Subject: Tree removal 50 and 51
Date: Monday, 27 September 2021 at 11:02:25 am Australian Eastern Standard Time
From: Aldo Donato
To: Anna Johnston
CC: John Green, Benjamin Wilderink
Attachments: 180128-LETTER-Sirius Building-Tree Removal - 23.09.27(Dedico).docx, image001.png, image002.png

From: Marie Burge <MBurge@cityofsydney.nsw.gov.au>
Sent: Tuesday, 21 September 2021 3:11 PM
To: John Green <jgreen@dedico.com.au>
Cc: Andrew Rees <arees@cityofsydney.nsw.gov.au>
Subject: RE: Sirius, 2-60 Cumberland Street, The Rocks - SSD10834 Modification

L-DA-09

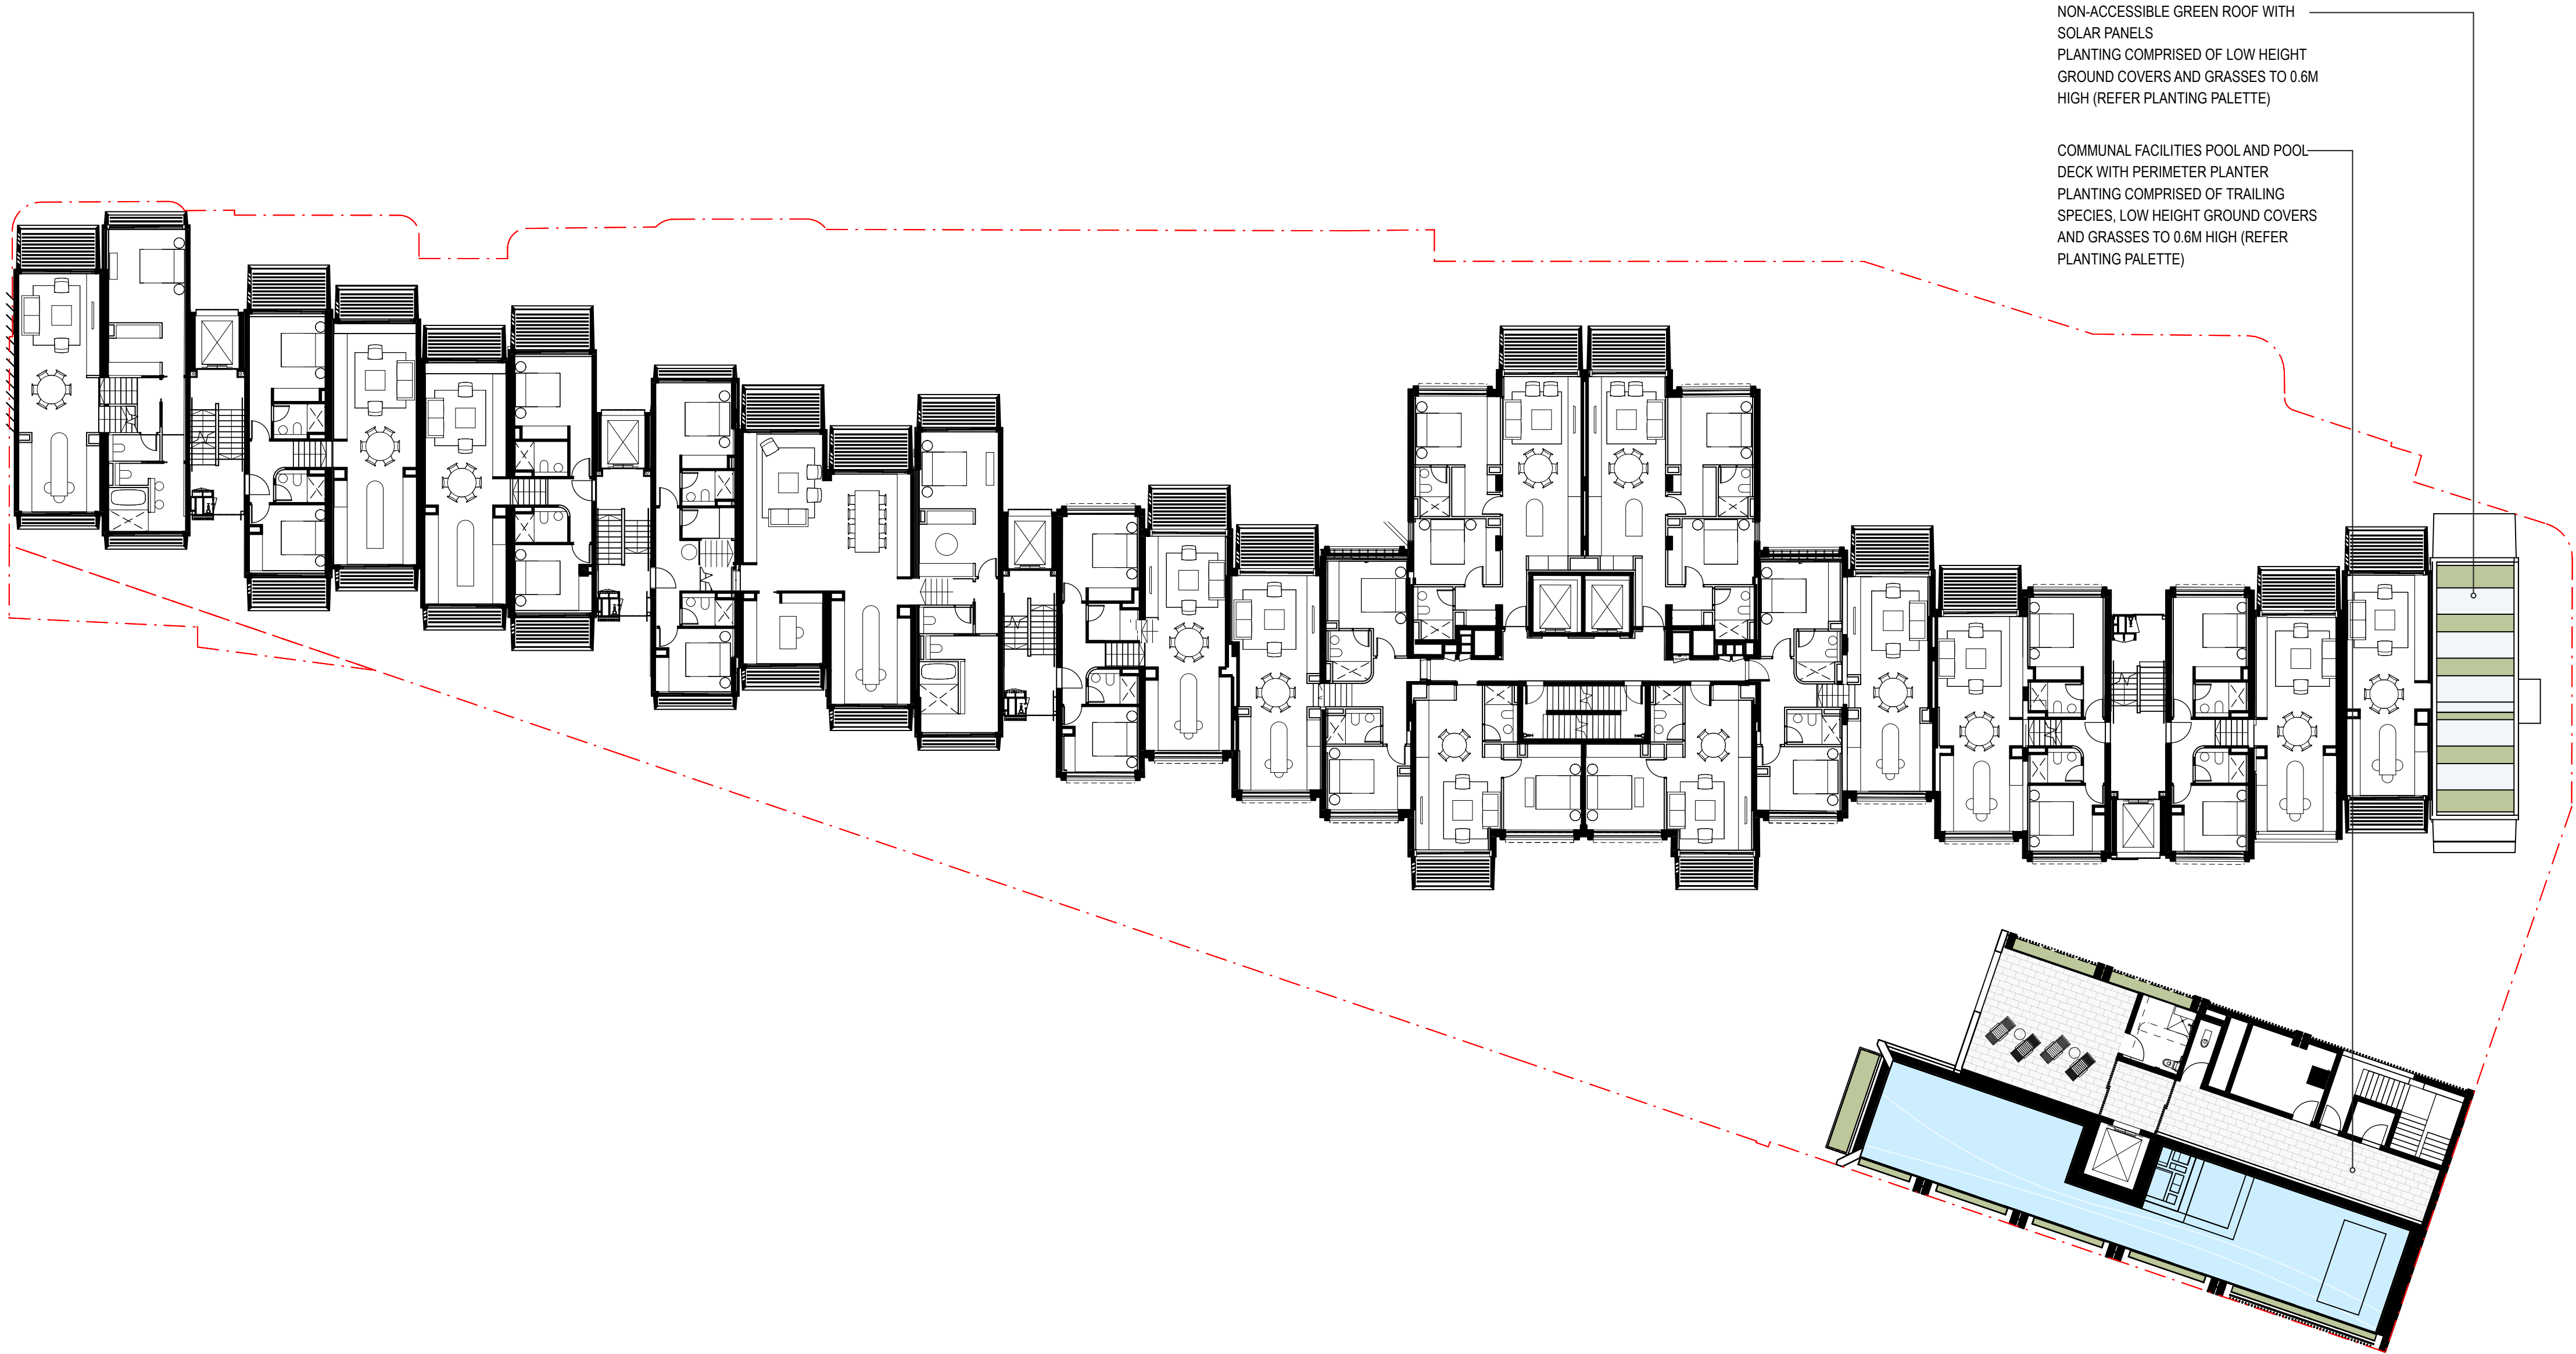
Overall, the removal of these High Landscape Value trees is not supported and it is recommended that you investigate alternative construction methods and designs to ensure the retention of these trees with input from a qualified AQF5 Arborist.

Trees 50 and 51 are considered to be High Landscape Value plane trees within Gloucester walk. It is Council's understanding that Trees 50 and 51 are located on Place Management NSW land and are not owned by the applicant.

It is understood that the removal of the trees are now recommended by your Arborist due to the removal of the retained material within the structural root zone of these tree. The Arborist has not provided any recommendations to allow for the retention of these trees. Relying on the fact that these works are within the theoretical Structural Root Zone and that they are affecting nearby paving as justification.

If this soil/retaining wall can be retained and the works conducted in a tree sensitive manner these trees can be retained.

Please find attached letter from SCP responding to councils note.

We are also getting a letter from the Arborist to support the structural note and referring to the tree roots blocking the adjacent stormwater line.
